Application Ref: H22-0077-25

Proposal: **Rural exception site of 24 affordable homes**

Location: **Land off Broadgate, Weston Hills, Spalding, PE12 6DB**

ADDITIONAL INFORMATION REQUIRED

DRAWING 1 Bedroom House
Plots 7 - 12
Floor Plans, Elevations and Typical
Section

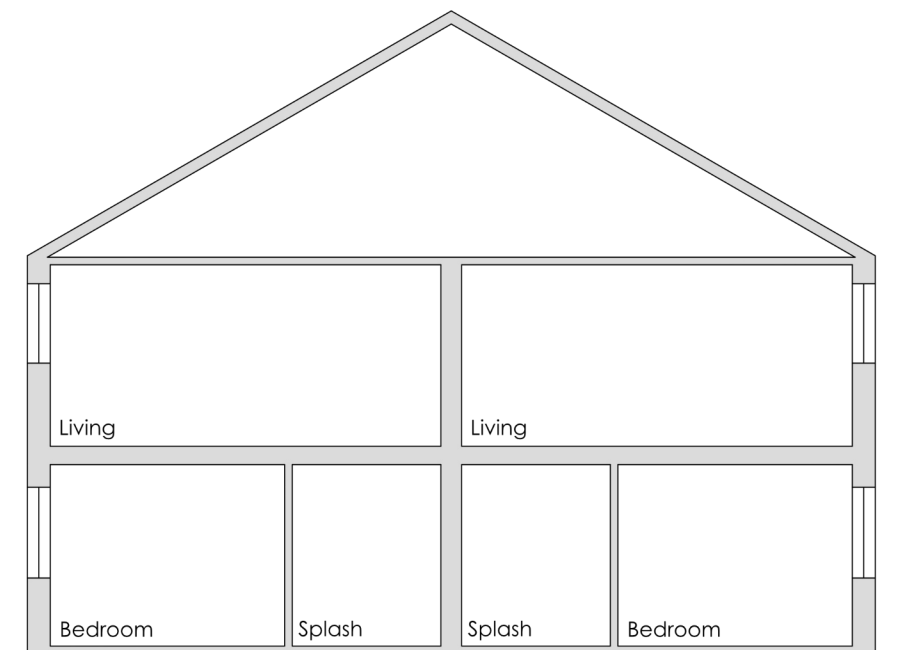
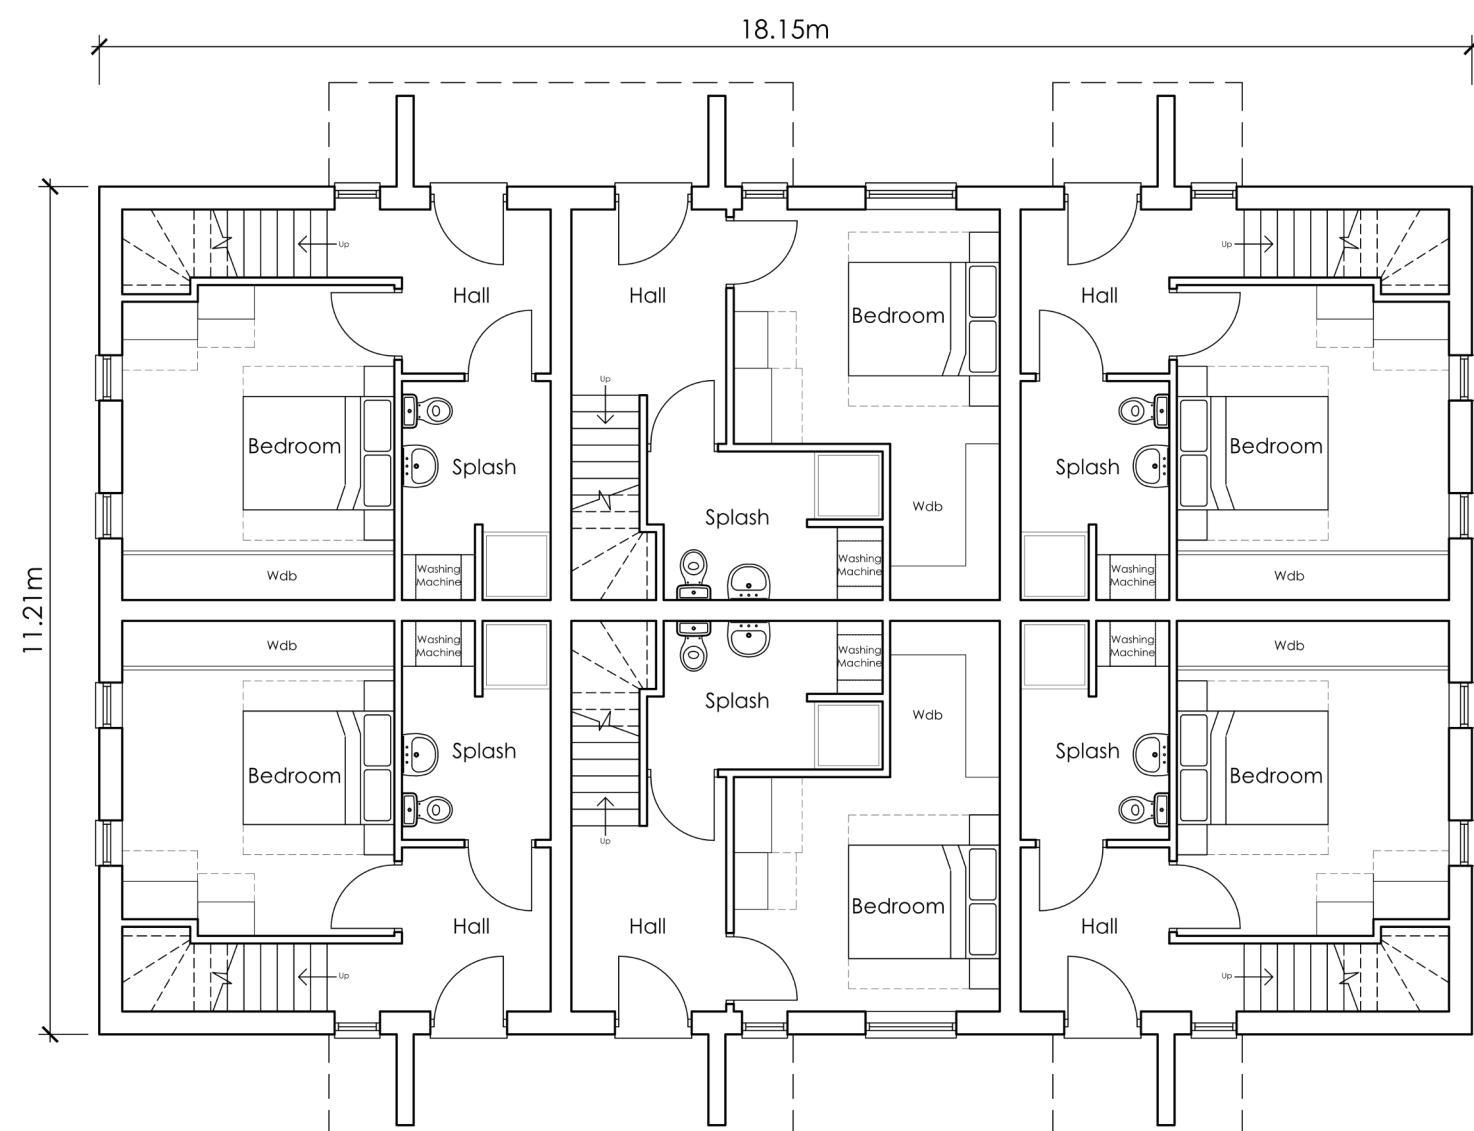
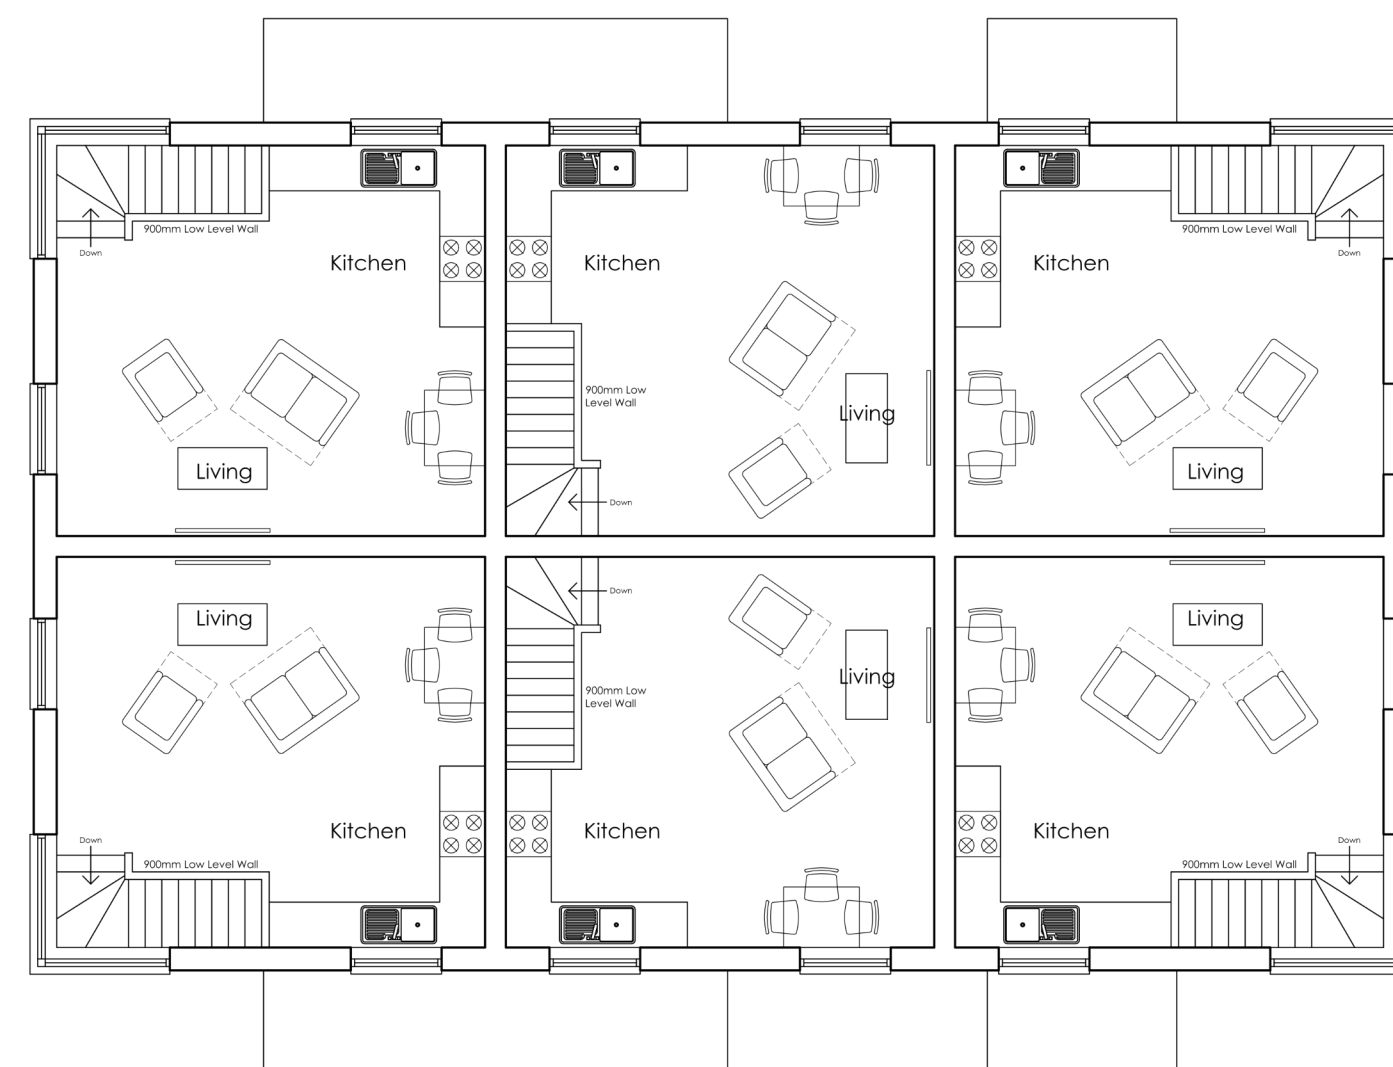
What are plots 7-12? They don't have their own garden space. The parking is too far away from some units and this will lead to indiscriminate parking in the area.

622.SL.01

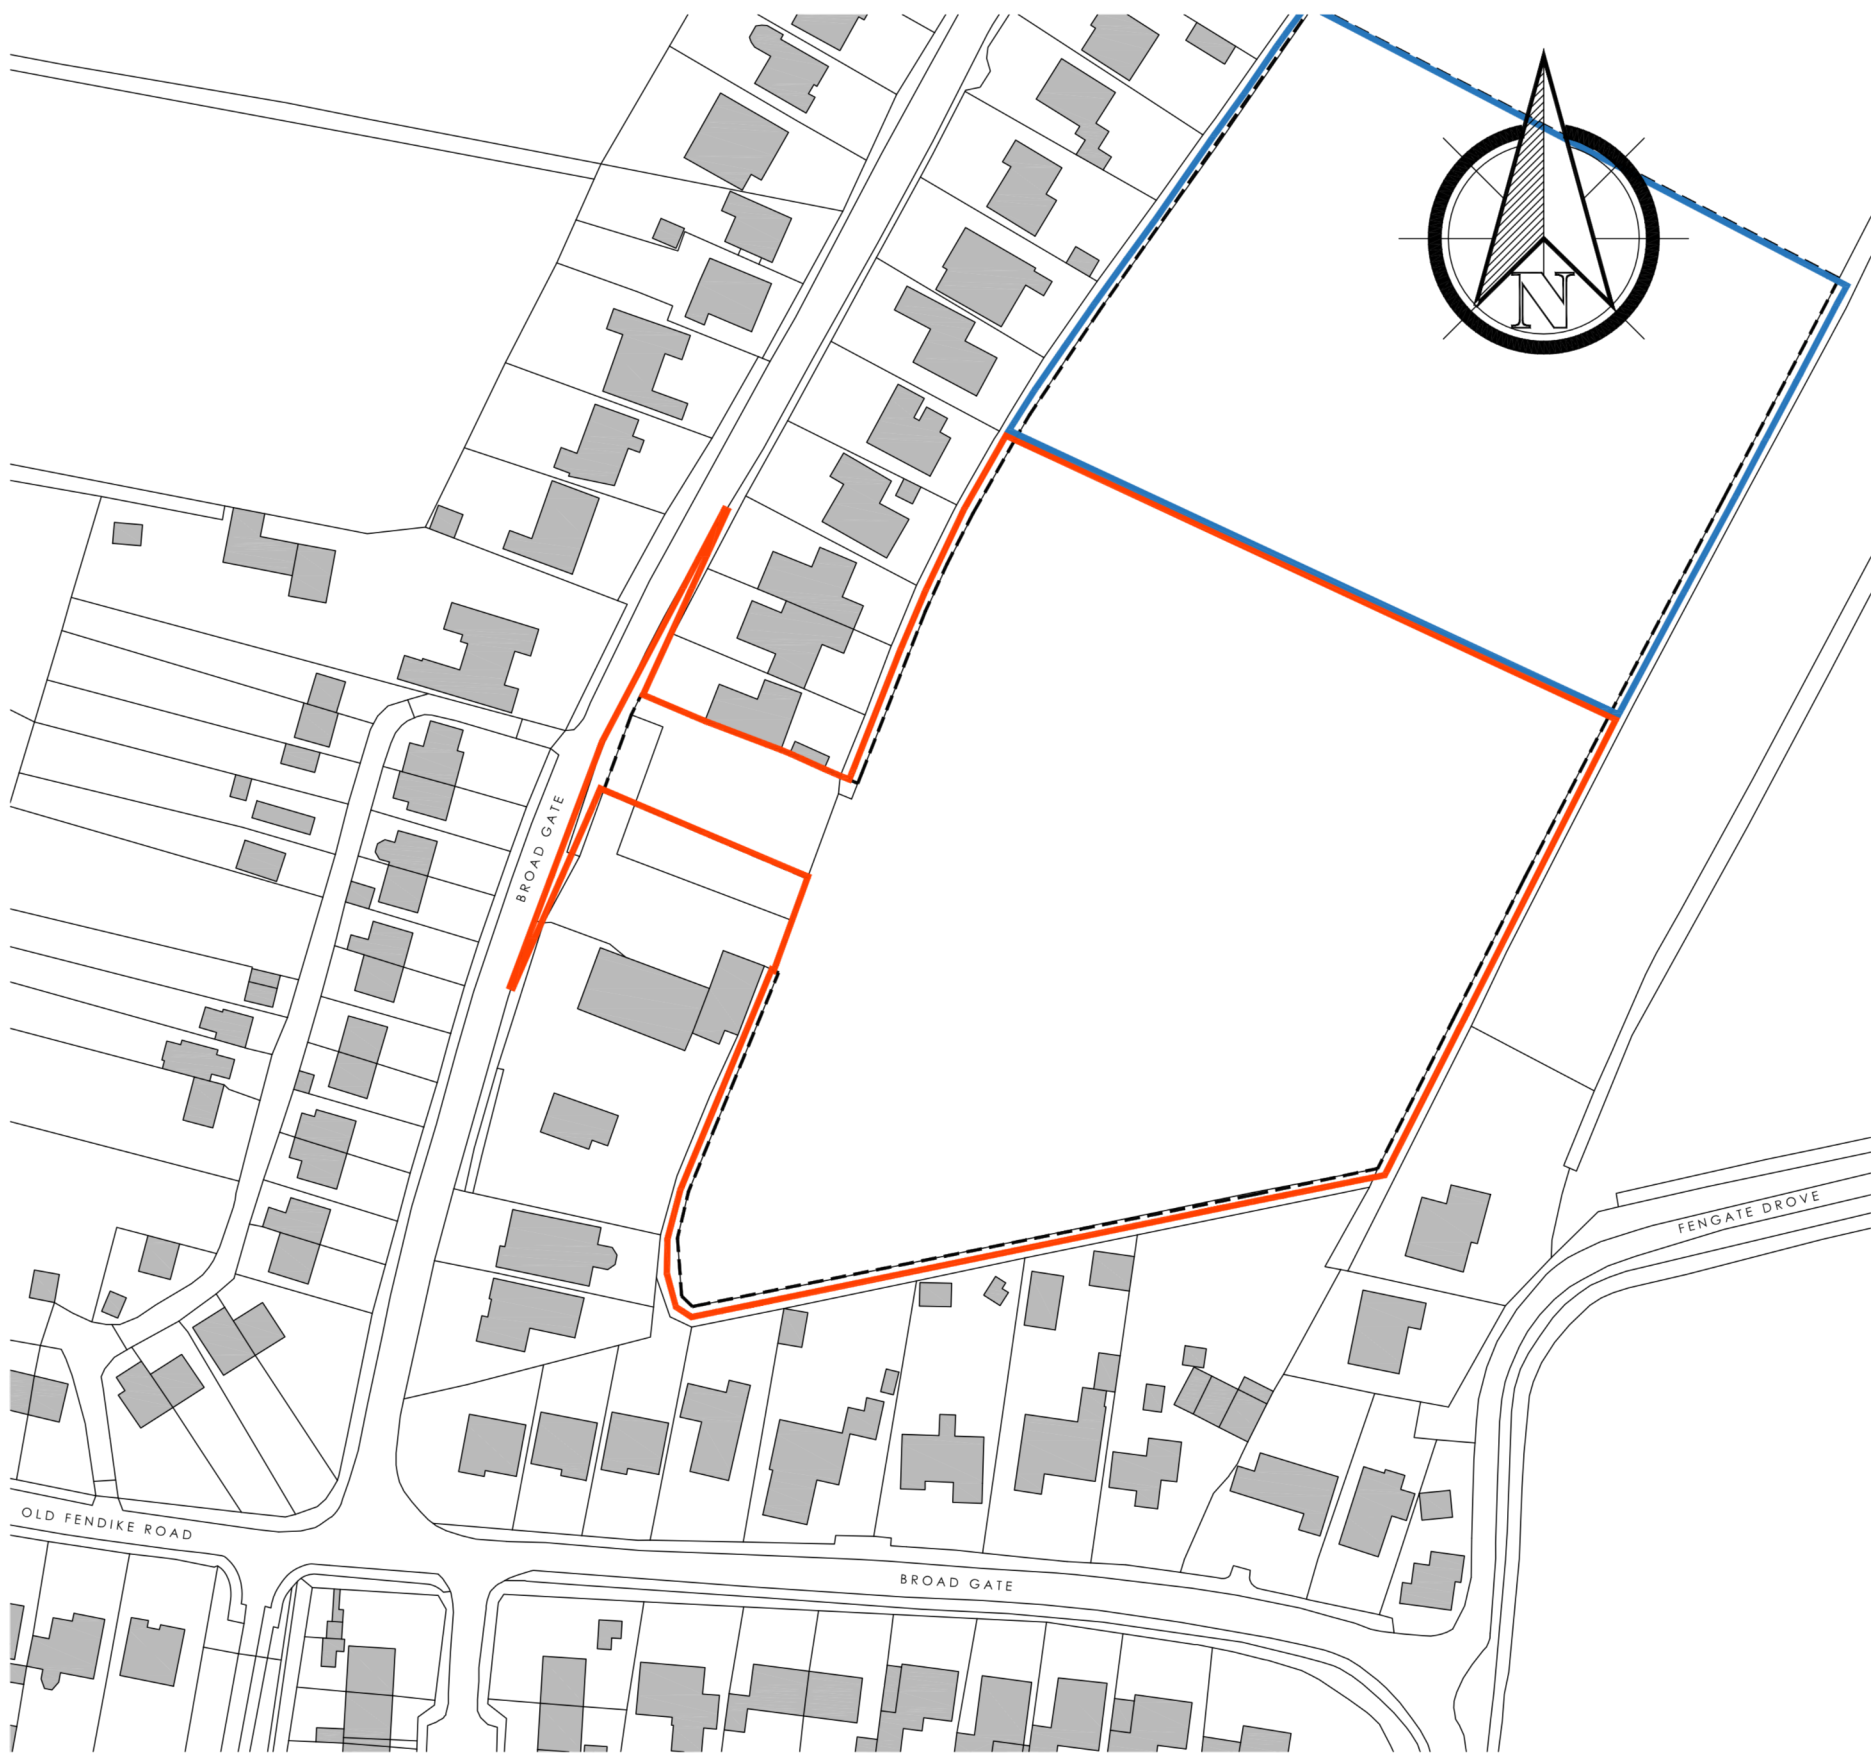
Carriageway and footway widths should be detailed on the site plan.

Central private drive to be changed to an edge lane to provide connectivity.

The footway at the end of the road close to plot 13 serves no purpose and should be removed – it only needs to go up to the drive way to plot 13.

Tactile paving should be detailed at every crossing point.

Secure Cycle storage should be detailed for every dwelling without a garage.

The footway that connects onto Broadgate should provide a tactile crossing over to the footway on the other side of Broadgate so pedestrians can access the existing footway network.

How will they maintain the ditches to the rear of the dwellings (plots 13-24).

They need to futureproof the design as the landowner owns the adjacent land (blue outline) – the attenuation pond should be big enough for both plots of land.
